RE: STATE SIGNIFICANT DEVELOPMENT APPLICATION (SSD 9601) FOR PROPOSED PLANT 2 UPGRADE WORKS

PROPERTY AT: 780 WALLGROVE ROAD, HORSLEY PARK (LOT 7 DP 1059698)

Following a review of the NSW DPIE’s request for the Response to Submissions (RTS), dated 9 March 2020, the matters raised have been taken into consideration and are accurately addressed in the response matrix that is attached to this letter. It is considered, that this information now provides the NSW DPIE with all the necessary facts and relevant particulars related to the Proposed Development subject to this SSD Application; thereby, enabling the assessment to be finalised and the Proposal determined.

Project	BRICKWORKS PLANT2 UPGRADE 780 WALLGROVE ROAD HORSLEY PARK
Title	SITWORKS AND STORMWATER DRAINAGE PLAN SHEET 4

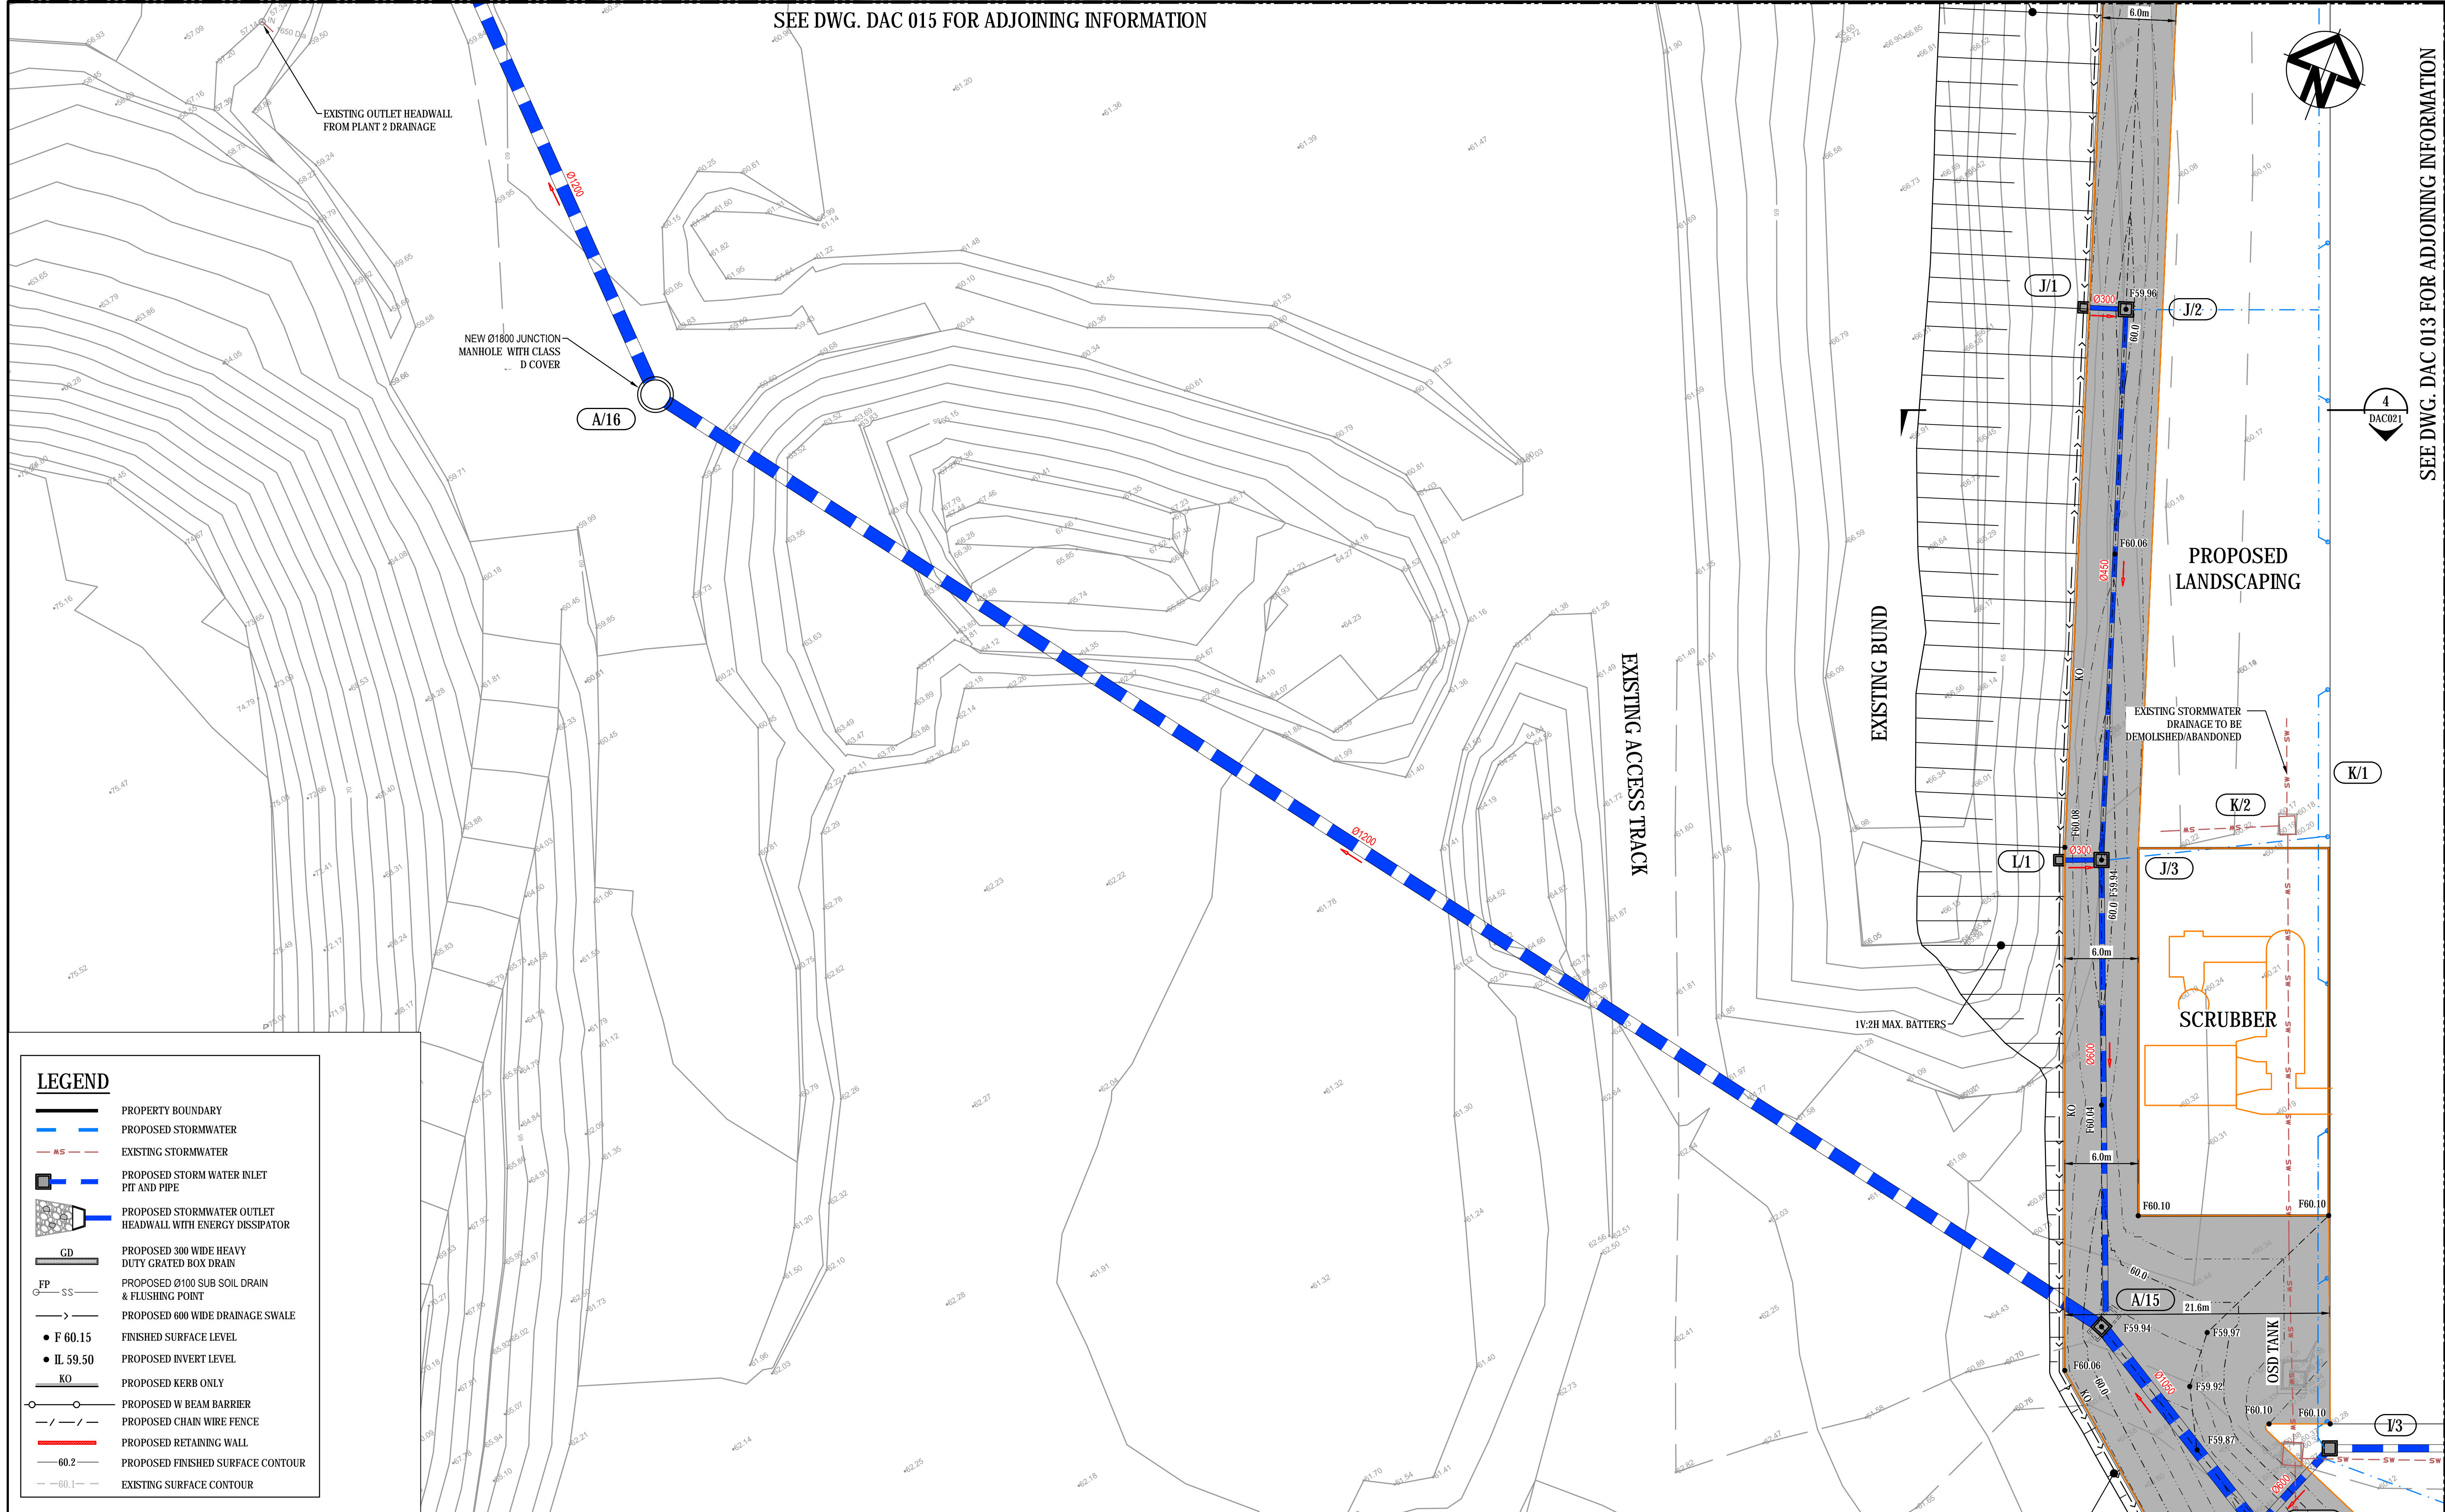
Relevant Entities Response to Submissions	Formalised Response																																																
<p>WaterNSW (Clay Preshaw – Manager Catchment Protection)</p>																																																	
<p>Pre and Post-Development Flows</p> <p><i>Our requirement that the post-development stormwater discharge flows must be equal to or lesser than current conditions stands. AT&L notes within table 8 of the response document that 'the quantity of flows into Eastern Creek are limited to equal or less than pre-development levels by the proposed OSD basin'; however no supporting evidence with results is provided to support this claim. Pre-development flows must be identified against post-development flows discharging offsite. Showing that the peak discharge flows meet the allowable permissible site discharge (PSD) requirements set by the local council is insufficient. As noted by AT&L, revised flood modelling would be the ideal process and is requested by WaterNSW.</i></p>	<p>Reference should be made to Table 3.4 (refer to extract below) of the revised <i>Soil & Water Management Plan and Civil Engineering Report (REP001-03-18-577)</i> prepared by AT&L (2020), which compares the pre-development flows with the post-development peak flows for all storm events between the 1% AEP and 63% AEP. This analysis has been undertaken with the DRAINS model (refer to Appendix 3). Accordingly, the post-development results are provided for the mitigated scenario involving installation of the proposed detention basin.</p> <p>Table 3.4 - Pre-Development vs Post-Development Peak Flow Comparison</p>

<p>PMF storm events is negative, indicating that a reduction in flood levels at these locations in the post-development scenario. Accordingly, the proposed development area is not directly affected by flood from Eastern Creek as shown in Figure 11 with the revised <i>Soil & Water Management Plan and Civil Engineering Report (REP001-03-18-577)</i> prepared by AT&L (2020).</p> <p>Furthermore, AT&L note, that no adverse flooding impacts are anticipated as a result of the proposed development for the following reasons:</p> <ol style="list-style-type: none">1. No works are proposed within the designated 1% AEP flood plain adjacent to Eastern Creek. There will not be any loss of flood storage or alterations to the flow paths of Eastern Creek.2. There will be no increase (actually a reduction) in localised peak stormwater flows coming from the development due to the provision of an on-site detention basin (refer to the extract above).3. All local stormwater runoff from roofs and hardstands will be captured and conveyed to discharge points by an underground piped network.
